From: [REDACTED]
Sent: 20 Sep 2023 05:41:49
To: Sonia.Payne@southnorfolkandbroadland.gov.uk
Cc:
Subject: RE: Invalid Planning Application 2023/1682
Attachments:

Having spoken with a senior planning officer, we require the east elevation showing the amendment to a scale of 1:100 or 1:50. Also the south elevation is required, showing the posts for the revised design of balcony. If they are not to scale, we will require for you to add the dimensions to all drawings.

WEST ELEVATION

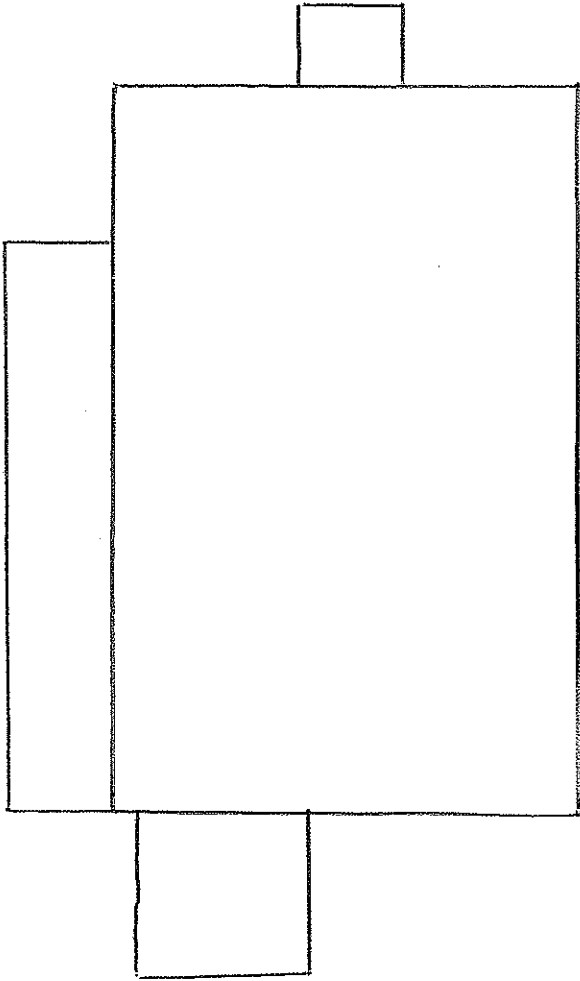
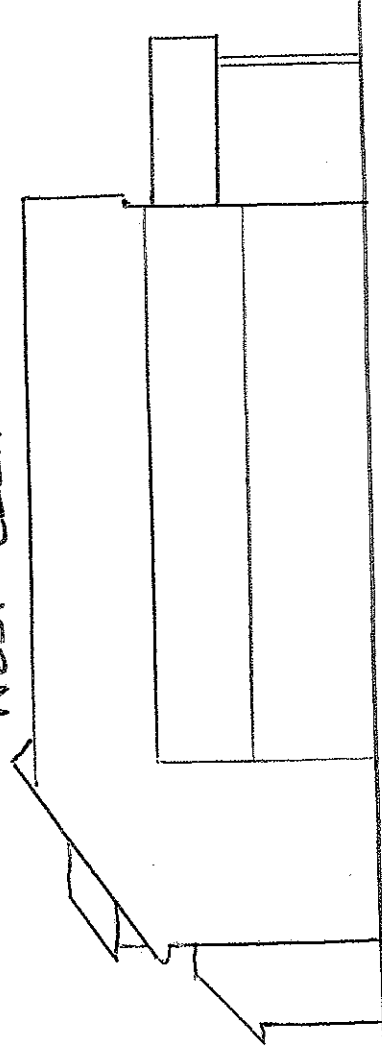
Unfortunately, we cannot accept the information that you have submitted for the requirements needed to proceed with the validation of your application. We do require scaled drawings showing the amendments as per me letter.

I can confirm we are just applying for the change in balcony. The rest of the extension is complete awaiting sign off (final internal fixtures outstanding). The South elevation has not changed from the original plans and therefore these can be used. As explained previously, the height and width have not altered, it is only the depth of the balcony which is detailed on the west elevation. The east elevation will show the same picture but I will send anyway.

Please see drawings attached drawn by myself – no copyright needed. I have attached a floor plan (bird's eye view) and West elevation as requested. The North and South elevations have not been altered as it is only the depth of the balcony that has changed, not the height or width.
